St Vincent's Capital Works Master Plan

St Vincent's Private Hospital East Wing Project

Design Workshop No 3
Record of Outcomes

Design Workshop No 4.
Record of Outcomes.

1 VICTORIA STREET ELEVATION
1:200

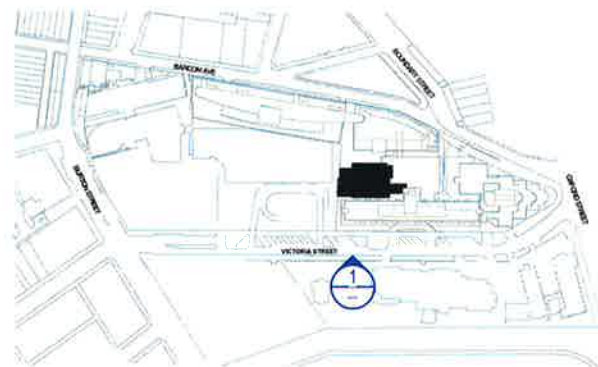
- _ Ensuite location to west facade of SVPHS will have significant street impacts to Victoria street. Physical set back reduced by nom 2.5 meters
- _ KM1 reinforced importance of addressing key City of Sydney issues of building proposition

- Street scale
 - Providing a greater sense of life to the ensuite faces. Inclusion of windows to west face of modules as a gesture
 - Responding to and acknowledging the heritage streetscape

- _ Ensuite location to west facade of SVPHS will have significant street impacts to Victoria street and requires integrated ordering device to structure composition

- _ Adoption of horizontal frames rather than complete frames preferred as ordering device that could also be adapted to East Wing
- _ Colour and pattern proposition referencing Plain trees good but delivery currently questionable. Review other options for colour and pattern configurations. Bar code pattern possible option

- _High light glazing strip (2000-2400 mm AFL) to ensuite modules provided to west face and side returns
- _Height and extent of this glazing limited by ensuite layout and ceiling height

- _Concern regarding extra cost of windows. If cost savings required windows to street facade to be maintained in lieu of returns
- _Accentuate horizontal frame to top and bottom by darkening parapet, spandrels to level 4 and 5 and precast pods to levels 4 and 5

1 EAST WING - WEST ELEVATION
1:200

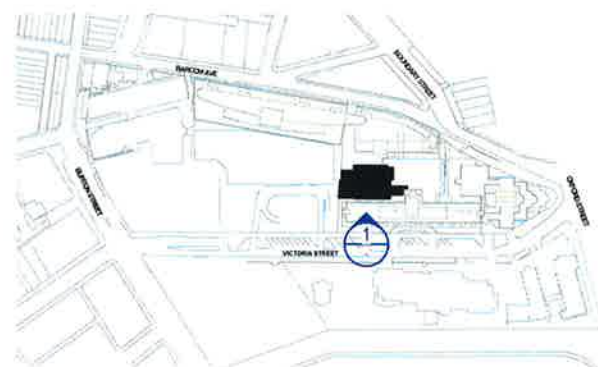
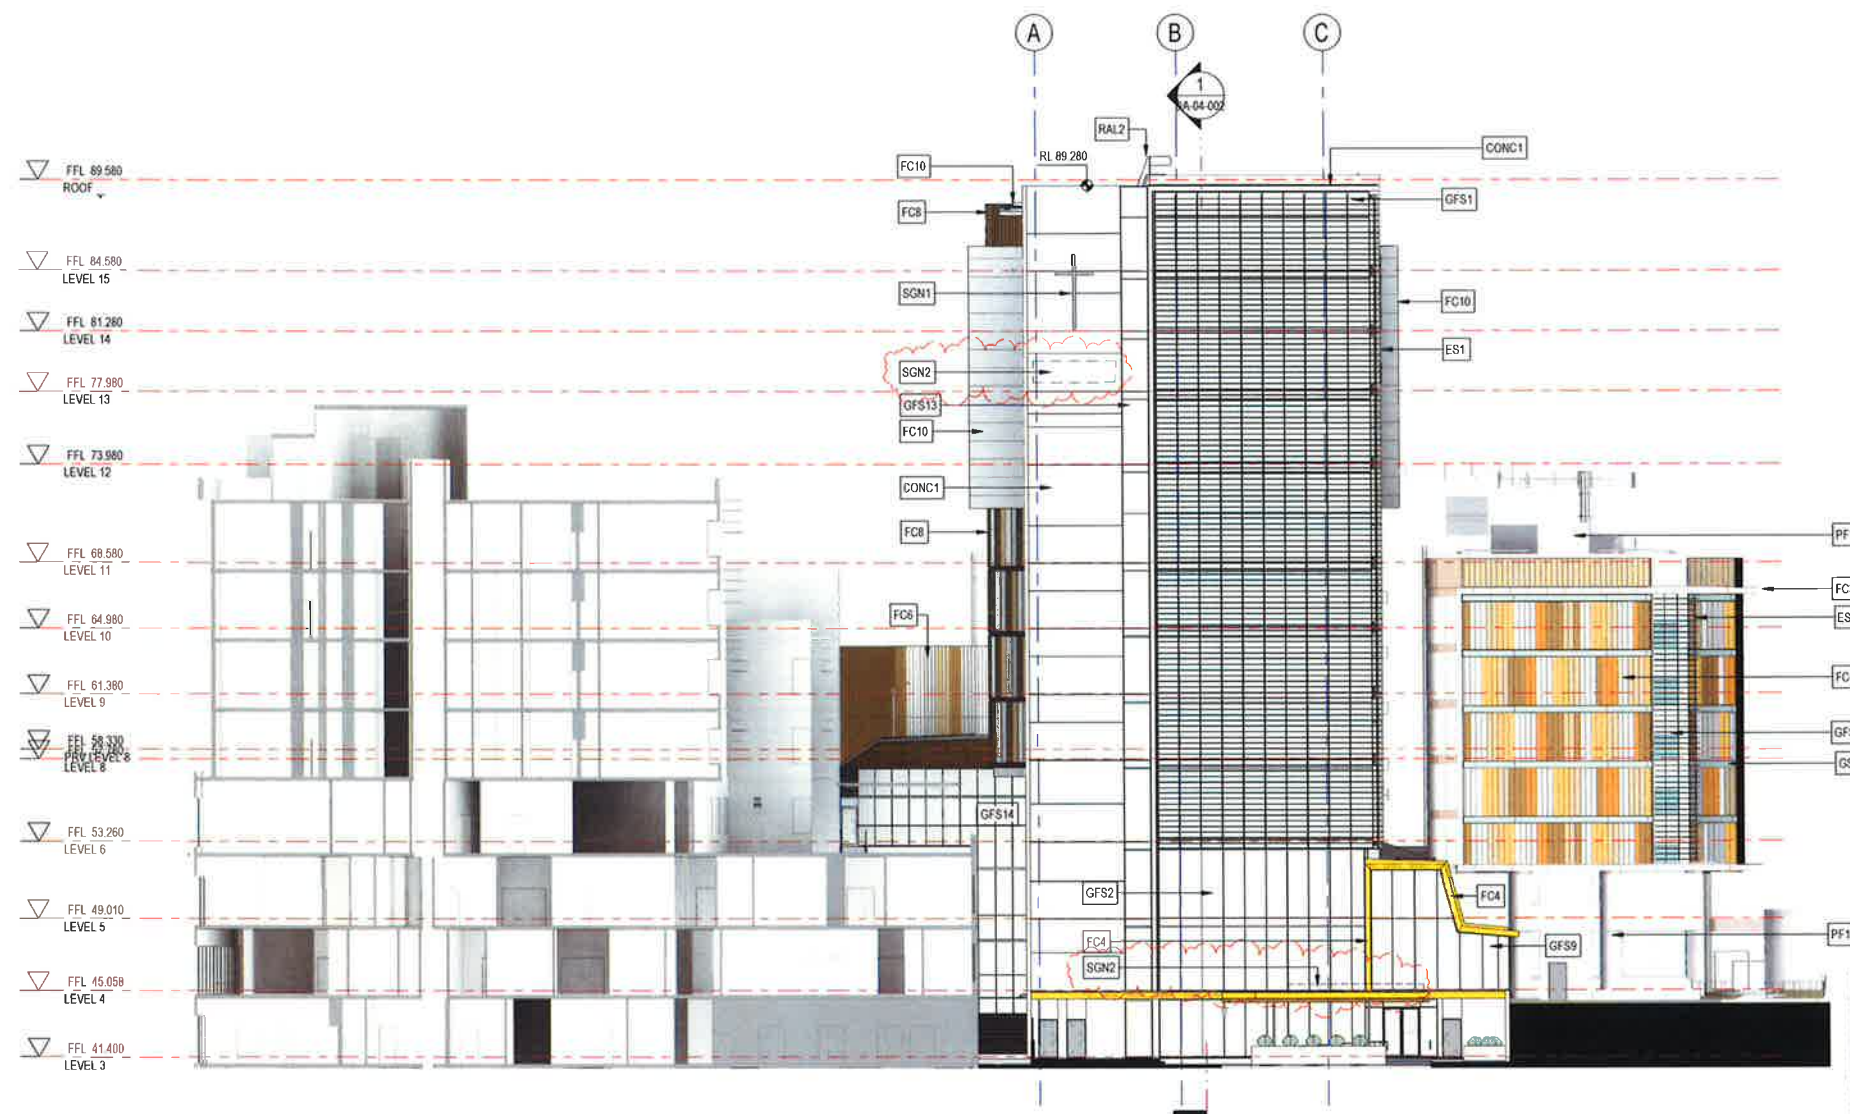
- _ Preference to express frame to upper three levels of East Wing as horizontals to top and bottom with vertical blades divided into three sections corresponding to floor levels

- _ Pattern and colour adopted to SVPHS ensuite modules to be applied to East Wing ensuites
- _ Termination of lift foyer glazing to top of East Wing building to be more dominant with possible use of additional framing member

- _ Escape stair wall could extend and be punctured at end of corridor to differentiate appearance from foyer
- _ Solar control device required to lift foyer glazing, integrated or external options available

- _ KM advised that horizontal blades to lift foyer facade should continue down to level 6 where transition of floor plate occurs. Sun control to level 3/4/5 to foyer to foyer glazing to be addressed

- _ Vertical blades to level 12/13/14 now divided into vertical segments
- _ KM still concerned about heaviness of blades and suggests that they are perforated to allow oblique view. Currently mullions are at 1333mm centres and blades at 666mm centres

- _ Glazing adjacent to north stair adjacent to lift foyer to be differentiated. KM suggestion to strengthen stair core and to express windows adjacent as a slot window

- _Provide solar protection to corner bedroom at levels 6-10 by provision of horizontal louvers to match East Tower lift foyer
- _Provide fine recess between vertical blades to East Tower and perforate vertical blades to improve oblique views out from levels 12,13 and 14
